Our Ref: 80009/PRC/2026/75

RE: Erection of part single part double side and rear extension, front and rear dormers, loft conversion, and front porch. Removal of trees
SITE: 5 Milton Road Ickenham

I refer to your request for pre-application planning advice dated 02-04-26 and our subsequent meeting on 01.06.2026 relating to the above development. The advice provided is based on the amended drawings provided on 08.06.2026.

drawing
EXISTING AND PROPOSED ELEVATION

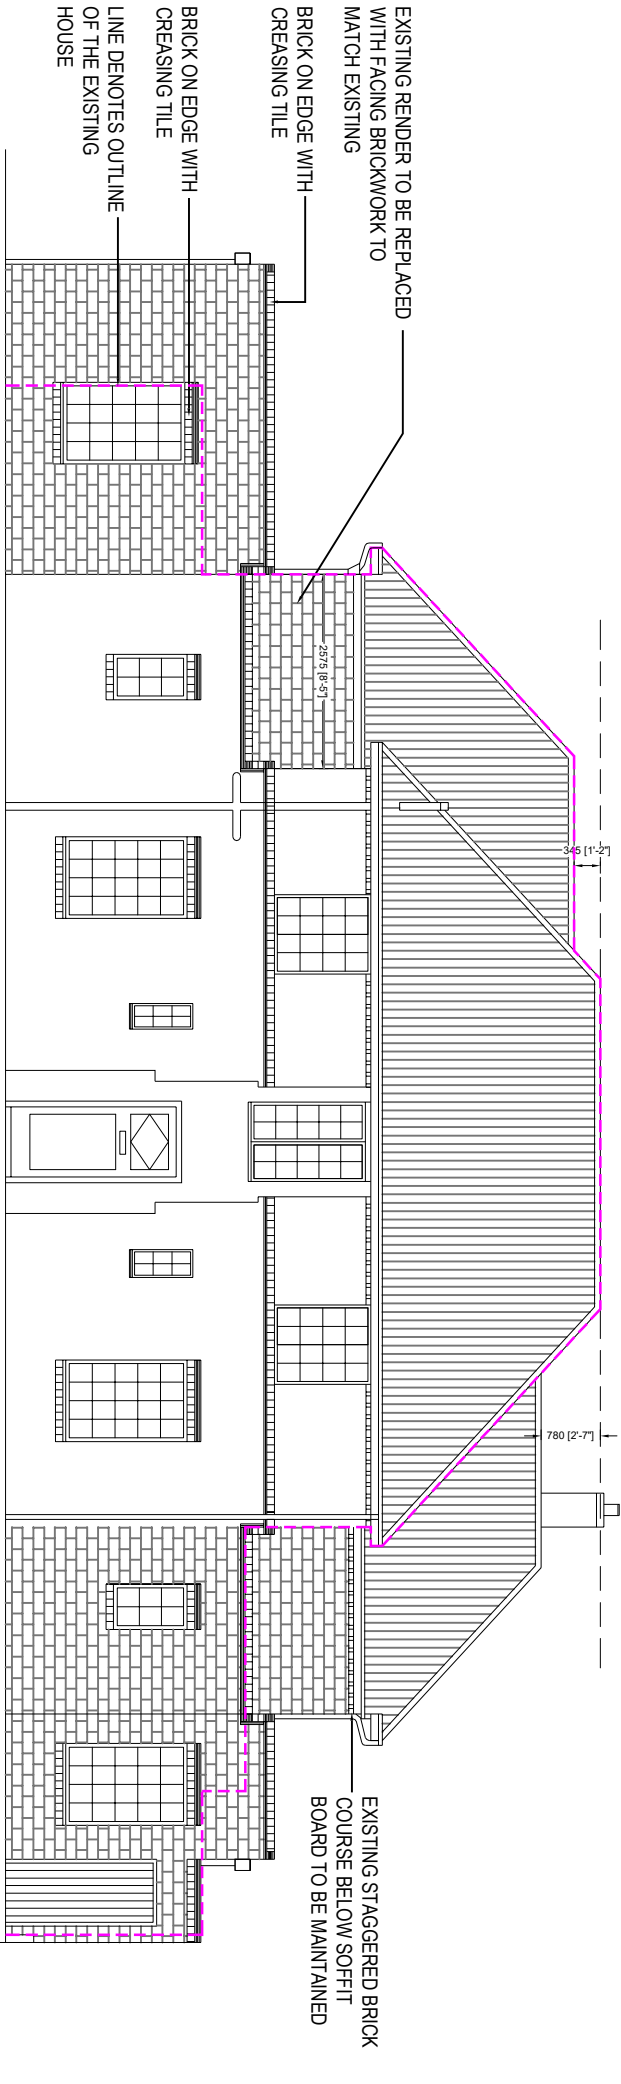
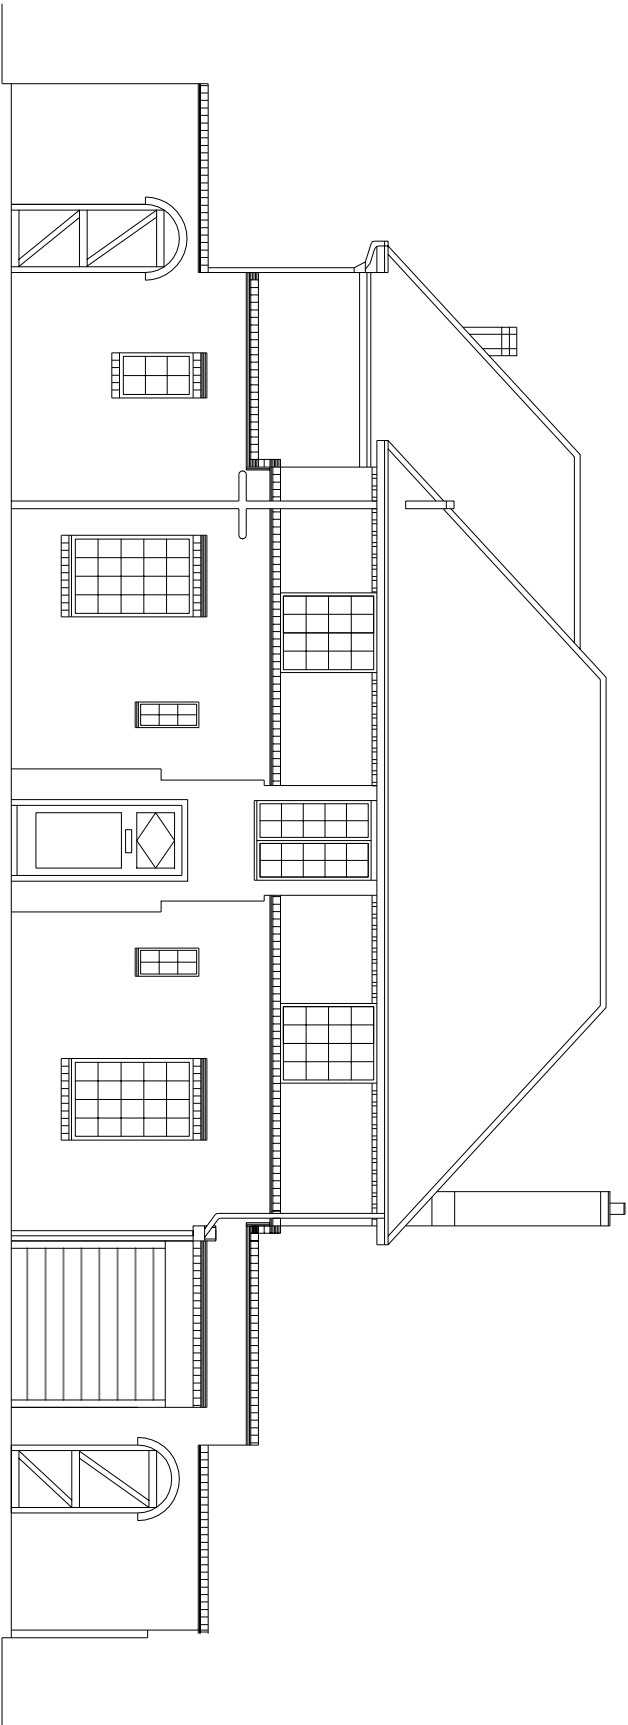
"There would still appear to be a need for substantial review. We would question if the conversion of the attic space is possible. A cut through section should be shown so we can review if there is enough habitable space to allow it to be used as a bedroom. We would also recommend that the dormer window to the faÃ??ade be removed. This also necessitates the removal of the chimney which we are opposed to. We would also question occupying the entire width of the plot. This is contrary to the general character of the conservation area with the gap spaces making important contributions to the dwellings and in addition the houses not built up to the pavement line as proposed in this application.

In relation to the design we would recommend that to the faÃ??ade that the design detail to the flank extensions have curved window heads and simpler windows that repeating the sash windows to the faÃ??ade. Similarly we would recommend that the parapet height ties in with the solder course at first floor level. To the flank elevation to Pepys close it lacks visual interest in particular at first floor level. It would be recommended to have a boundary brick wall to Pepys close rather than the close boarded fence. This would help the integration of the alterations.

PROPOSED LOFT PLAN

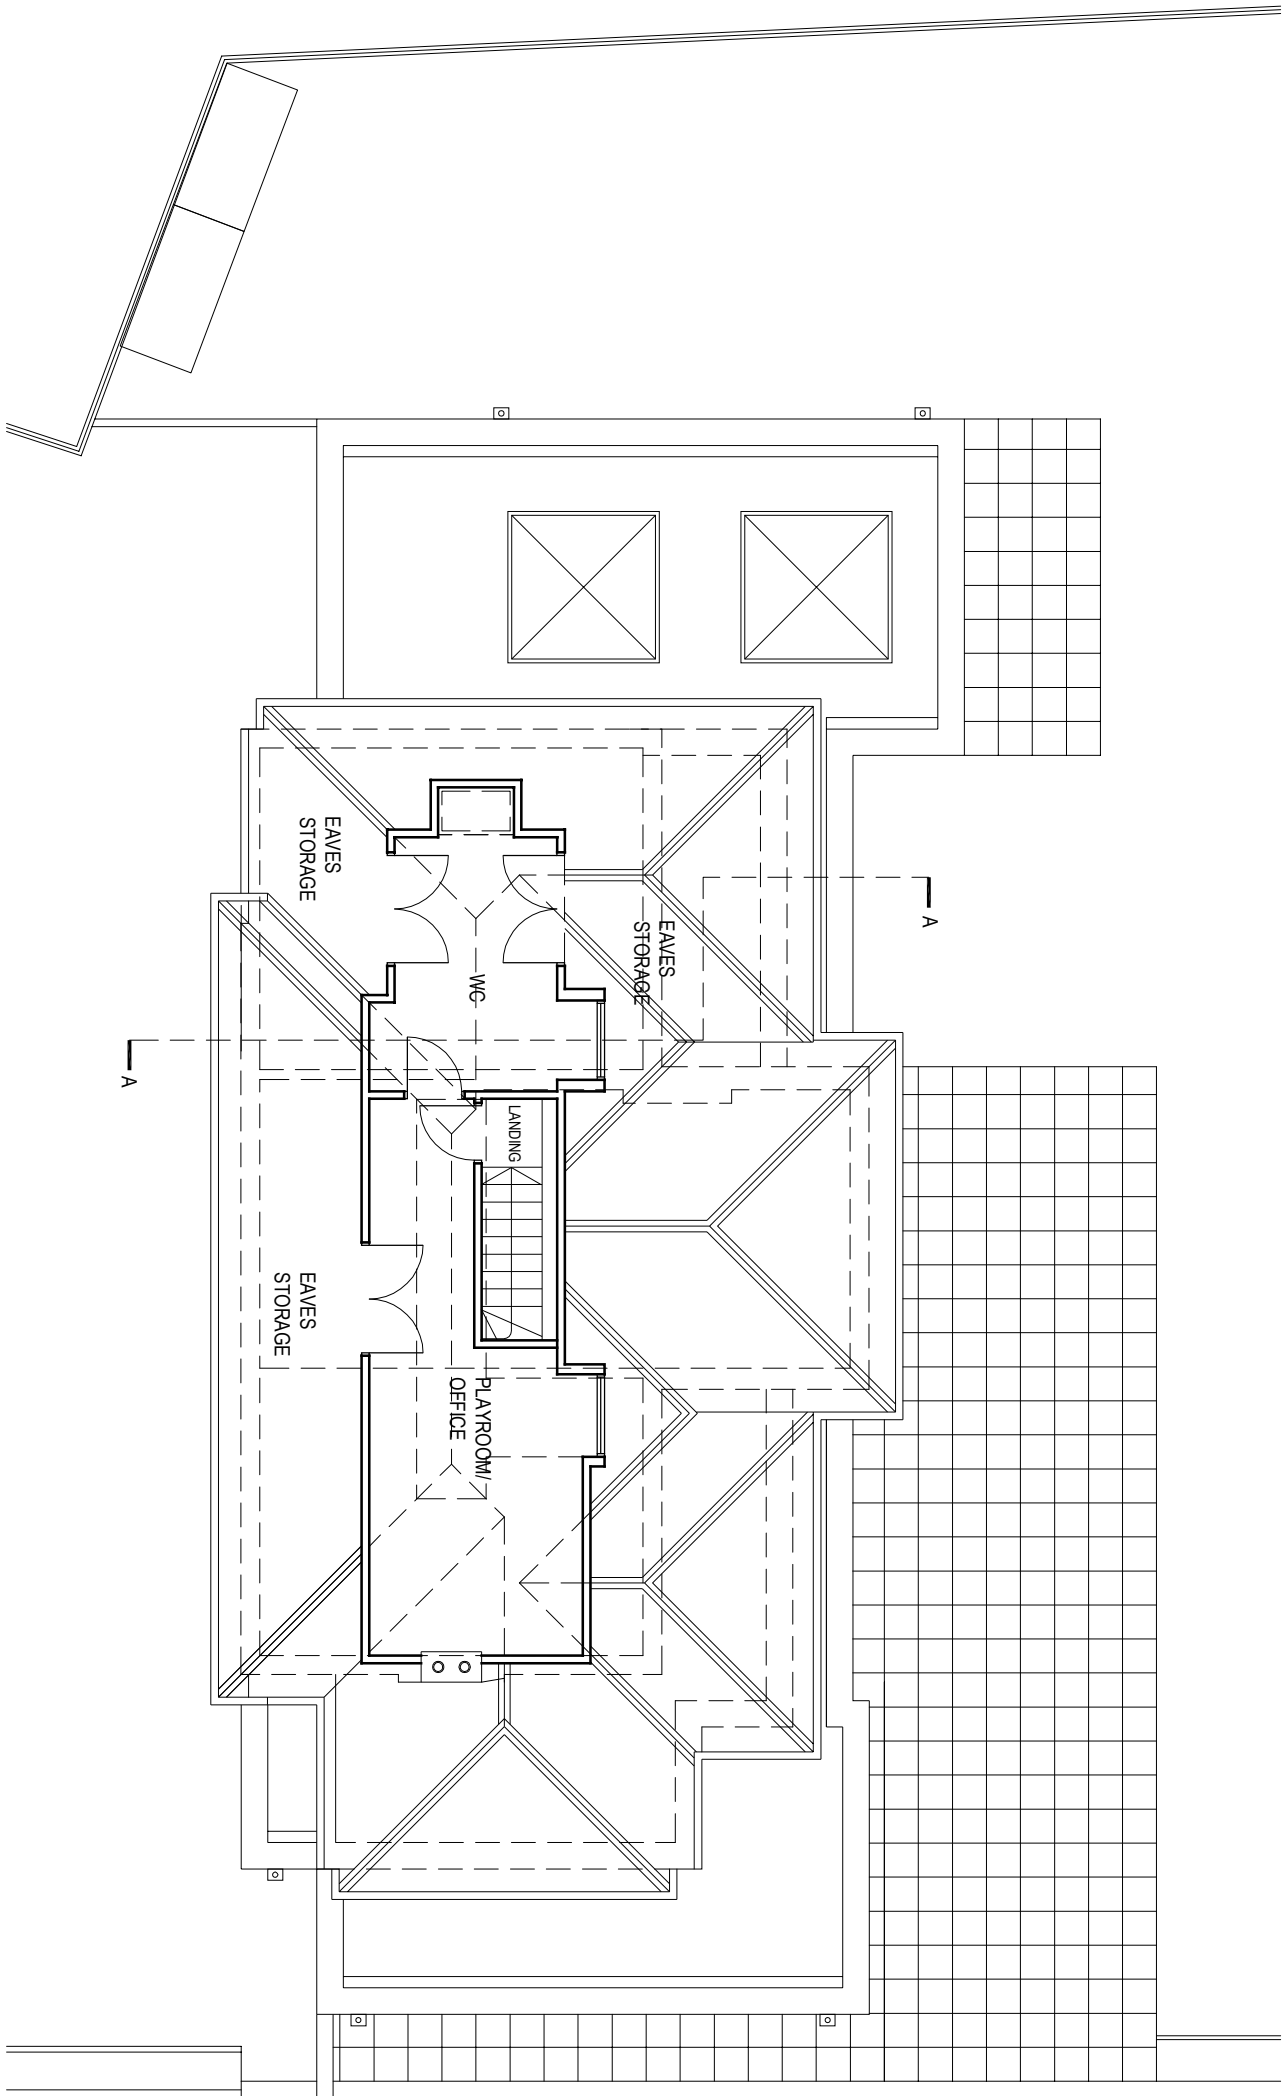
Notwithstanding the above, it is considered that the proposed attic conversion demonstrated on the drawings is likely to cause harm to the amenity of the occupiers at the subject dwelling. The long and thin layout of that bedroom is unlikely to provide adequate natural light to the space, and it represents an inconveniently shaped living accommodation. It is also noted here that the internal ceiling heights of this room are not demonstrated on the drawings, thus it is not possible to measure the floorspace of the bedroom above which the ceiling height would be over 1.5m.

It is therefore considered that, at present, the proposal would conflict with the above policies in respect of the amenity space provided to the occupiers of the habitable room on the second floor of the dwellinghouse at 5 Milton Road, as proposed.
